National Infrastructure Directorate
Planning Inspectorate
Temple Quay House
Temple Quay
Bristol
BS1 6PN

Our ref: RA/2015/131206/02-L03
Your ref: EN10048
Our ID: 10030429
Date: 20 May 2015

RELEVANT REPRESENTATION SUMMARY

THE WHITE ROSE CCS (GENERATING STATION) DEVELOPMENT CONSENT ORDER. LAND WITHIN AND ADJACENT TO THE DRAX POWER STATION SITE, DRAX, NEAR SELBY, NORTH YORKSHIRE.

Figure 1 Landscape and ecology mitigation plan

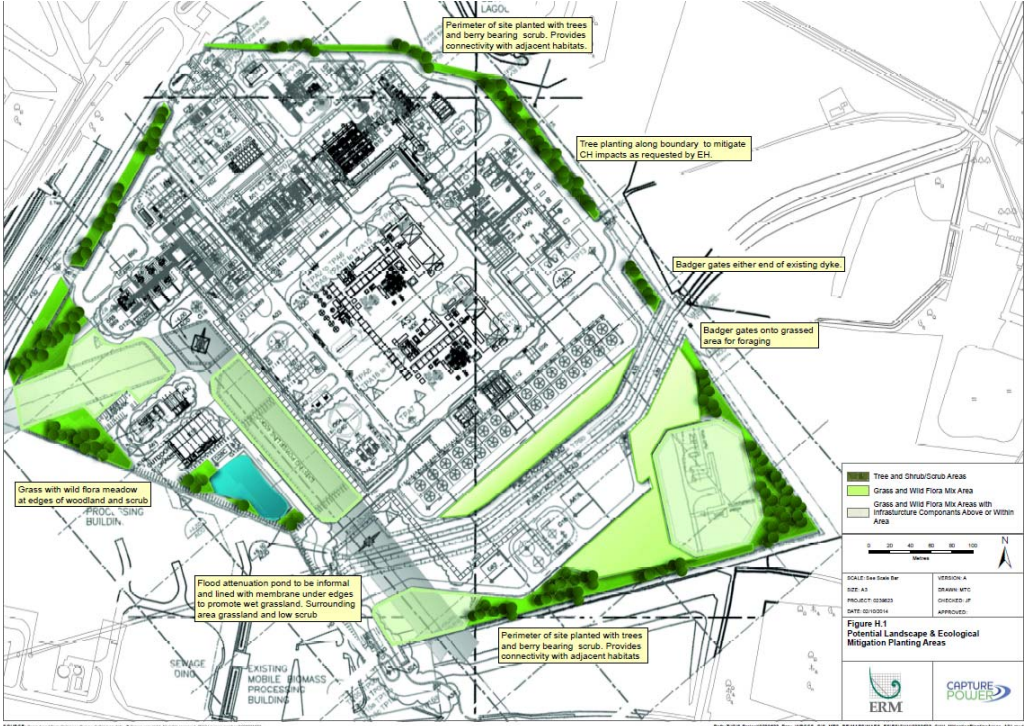
- We have reviewed the project's impact on water-related biodiversity;
- Matters of terrestrial ecology fall outside our remit;
- The ecological enhancement measures currently proposed are inadequate, vague and open-ended;
- We request a schedule of biodiversity mitigation and enhancement measures to which the applicant is committed.
